**KIRKLEES METROPOLITAN COUNCIL  
INVESTMENT & REGENERATION SERVICE**

**DELEGATED DECISION TO DETERMINE PLANNING APPLICATIONS**

Reference No:	<b>2023/60/92215/E</b>
Site Address:	land off, Woodside Lane, Fixby, Huddersfield, HD2 2HA
Description:	Outline application for erection of residential development
Recommending Officer:	Tom Hunt

**DECISION – REFUSE OUTLINE PLANNING PERMISSION**

**2 Proposed Front Elevation**  
1 : 50

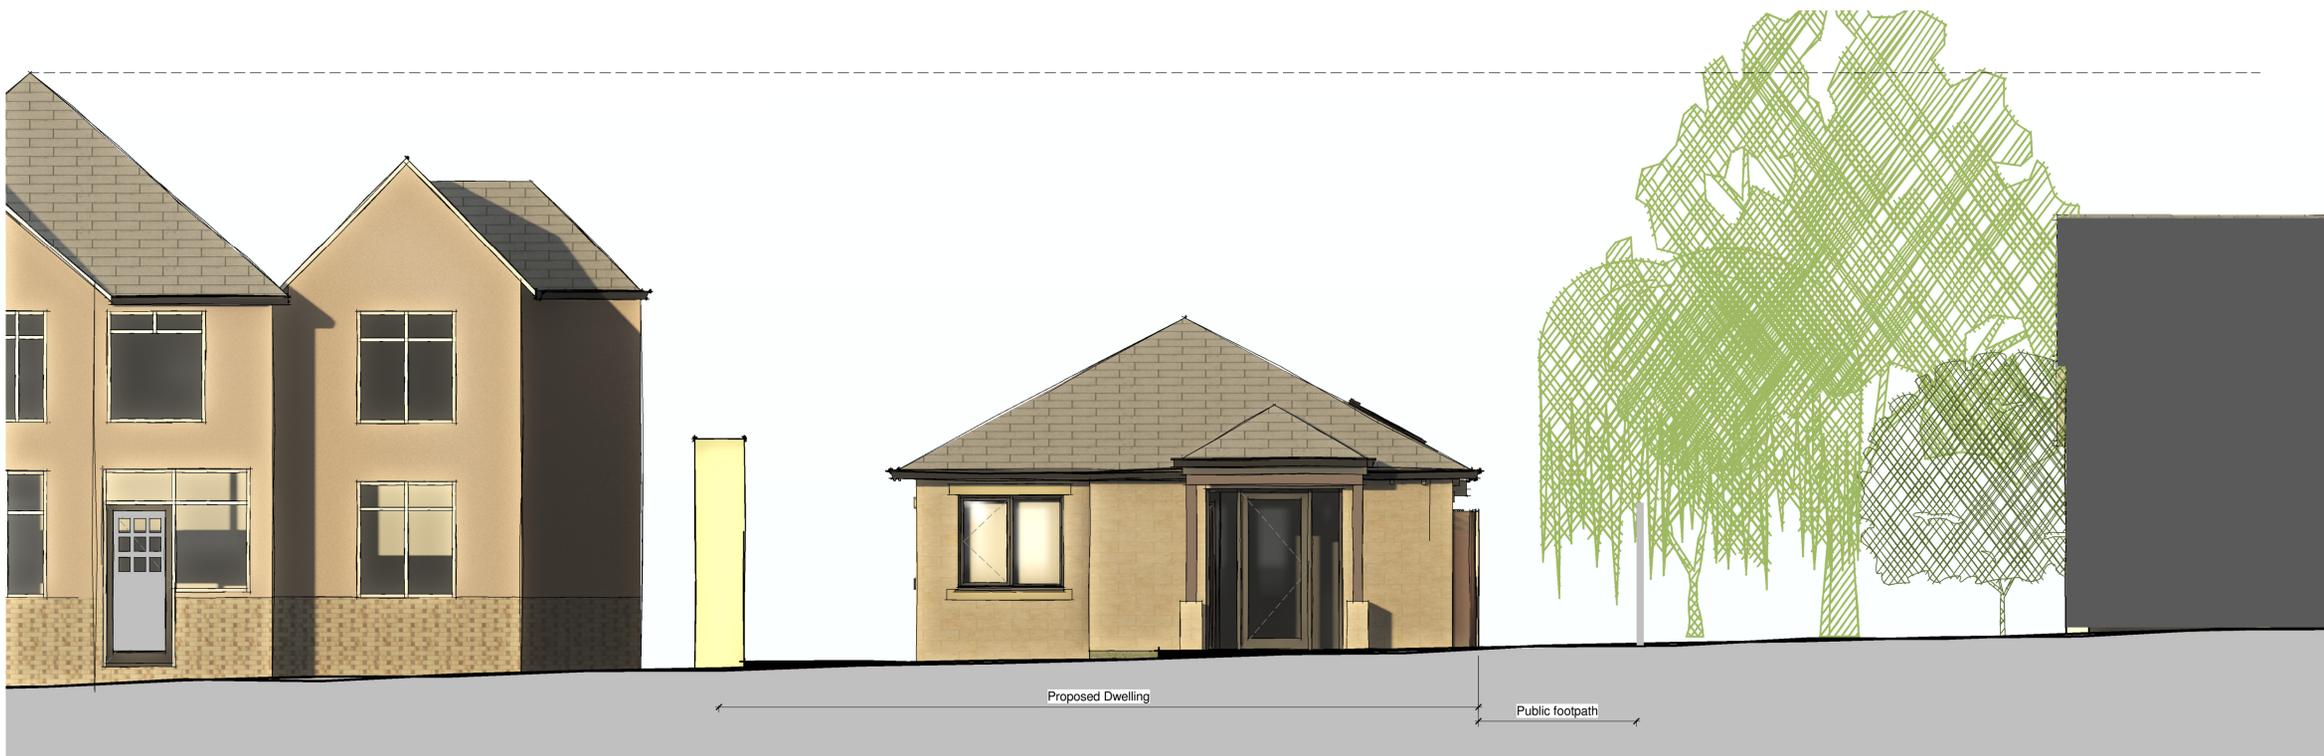
The scale of the main body of the bungalow would be 12.1m depth x 9.5m width. It would have a hipped roof with an overall height of 4.7m and 2.5m eaves height from ground level. Its front entrance would appear with a small, hipped roof canopy. The main body would have a single-storey flat roof projection extending 3.3m from the rear with 5.1m width to match the eaves height of the building positioned to the southwest flank boundary. This would have a property with an overall depth of 15.6m closely matching the overall depth of no. 3 when taken with its large main body and its various extensions.

Whilst the proposed pitch roof design and its single-storey scale would reduce some of the bulk and massing to the boundary, this would appear overly narrow and of an incongruous scale in between the wider two-storey dwellings as demonstrated by its contrasting reduced roofline, narrowly proportioned width and excessive depth. This would appear even more visually jarring with the lack of an adequate separation distance to the northwest boundary eroding the attractive and visual sense of openness in the locality.

Principle 5 requires cornerplots to have active frontages to provide visual interest. The placement of windows to its northwest elevation fronting onto the footpath would appear visually jarring encroaching on the footpath and would introduce an uneasy and alien relationship between users and occupants with privacy. Even as this could be conditioned to be obscurely glazed to mitigate its effects on privacy, this would still appear to be a contrived and uneasy solution. An alternate solution to a windowless side elevation would contribute towards the excessive depth of the dwelling to appear more visually overbearing. The lack of defensible space or separation to the boundary on the indicative siting emphasises that standard design solutions would not be in keeping with the character and appearance of the locality. As such, whilst materials are acceptable the design would not be sufficient to outweigh Officers concerns regarding the incongruous scale and appearance of the proposed dwellinghouse.

Drawing UD-488-01 Revision:

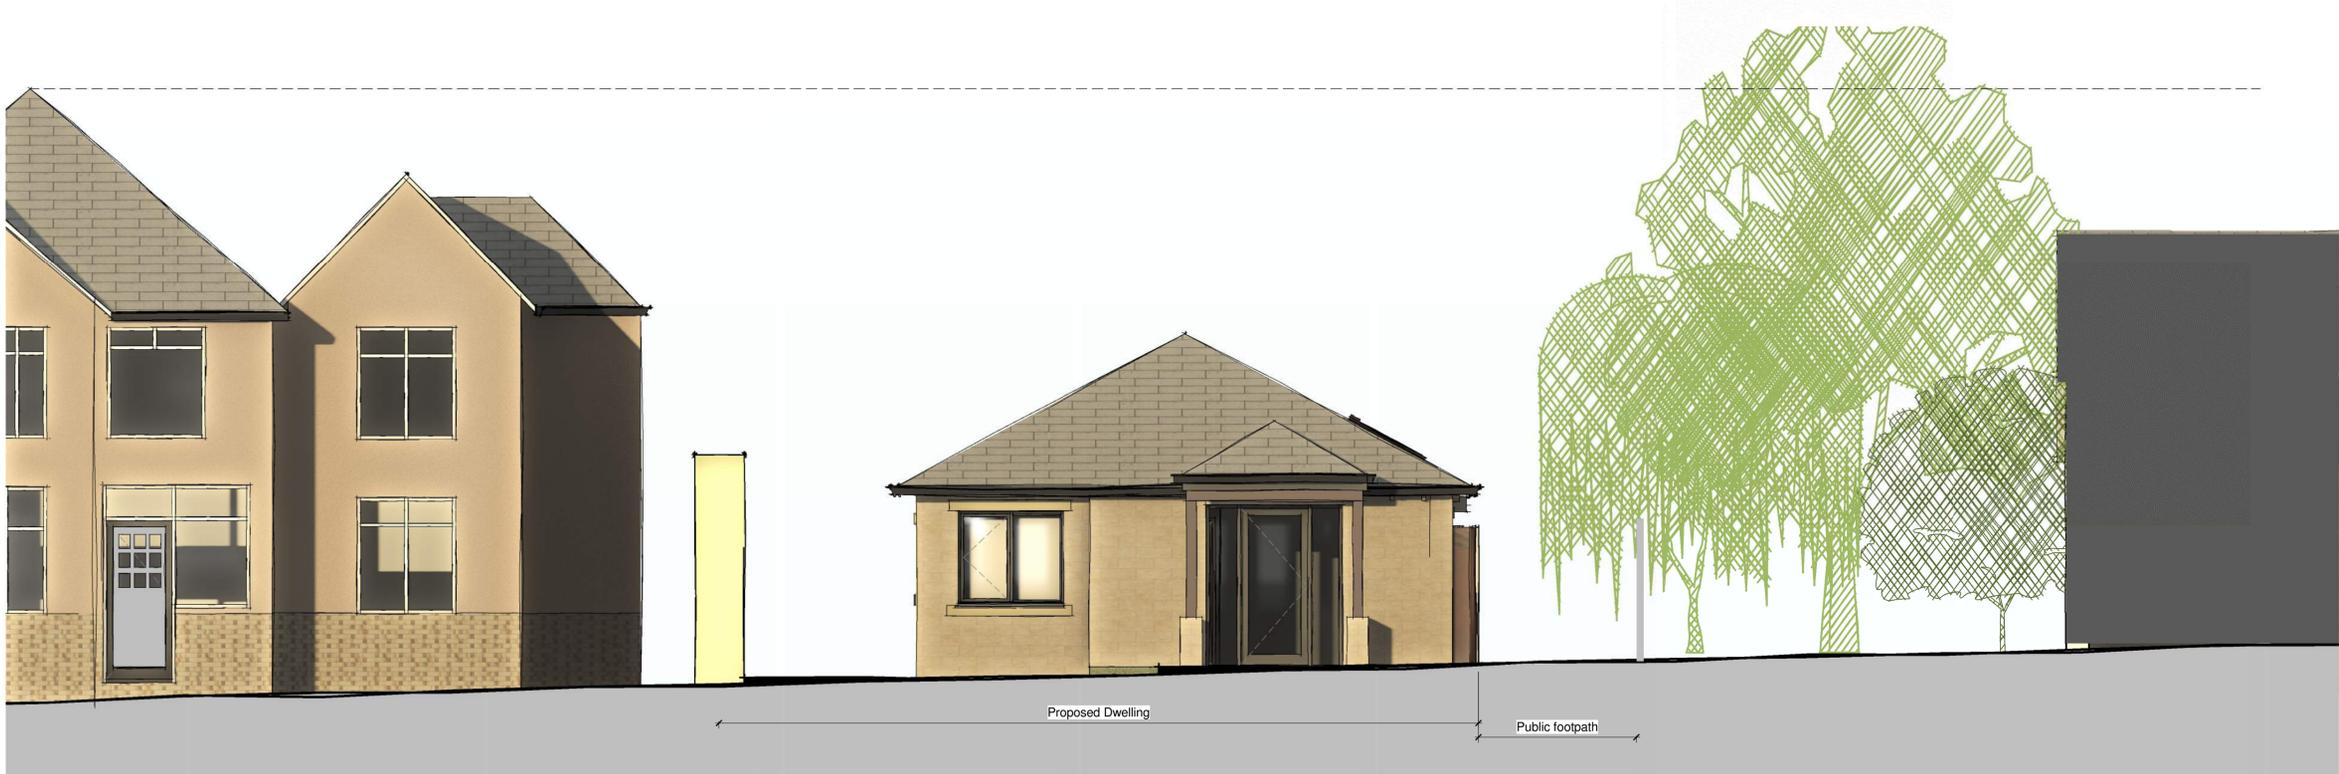
The proposal is for a bungalow mainly set back 17.6m from the highway. The indicative layout shows it to be positioned on the southwest flank boundary and have a separation distance of 2.7m from the northeast flank boundary. There would be a 14.5m separation distance to the rear garden boundary.

The proposal would lead to a single-storey, detached, bungalow dwelling with a modest single-storey projection with an overall depth of 15.6m. This would appear to be of considerably elongated and narrow appearance to those present within the two neighbouring large detached two-storey neighbours. It is indicatively shown to be positioned on the northwest boundary with 1.8m height from ground, close boarded timber fencing to the boundary; the lack of a separation distance and its depth would lead to an overly close, contrived and cramped appearance leading to a visually overbearing feature to the users of the footpath. Whilst layout is a reserved matter, the illustrative site plan and the details of scale and appearance applied for shows that this dwelling could not be sited within the plot without appearing cramped and contrived.

Whilst it could be considered that the footpath would allow a visual sense of openness to the northwest boundary, the placement of the dwellinghouse on the flank boundary/close thereto would appear visually contrived, over engineered and uncharacteristic with built development in the locality benefiting from an adequate property gap to flank boundaries.

The dwellinghouse would have an adequate set back from the lane to retain some sense of openness within its setting. It is proposed to have a large area of hardstanding for parking and the turning area adjacent to the highway with some landscaping immediately to the front of the property. This extensive

area of hardstanding would create a visually stark, car dominated and uncharacteristic appearance to the front. This would appear to contrast significantly with the established characteristic appearance of its neighbouring properties with landscaping to the front and side of their driveways softening the visual impact of the hardstanding. The indicative landscaping proposed would not adequately soften the visual starkness of the hardstanding to the frontage and be contrary to Principle 12 of the SPD.
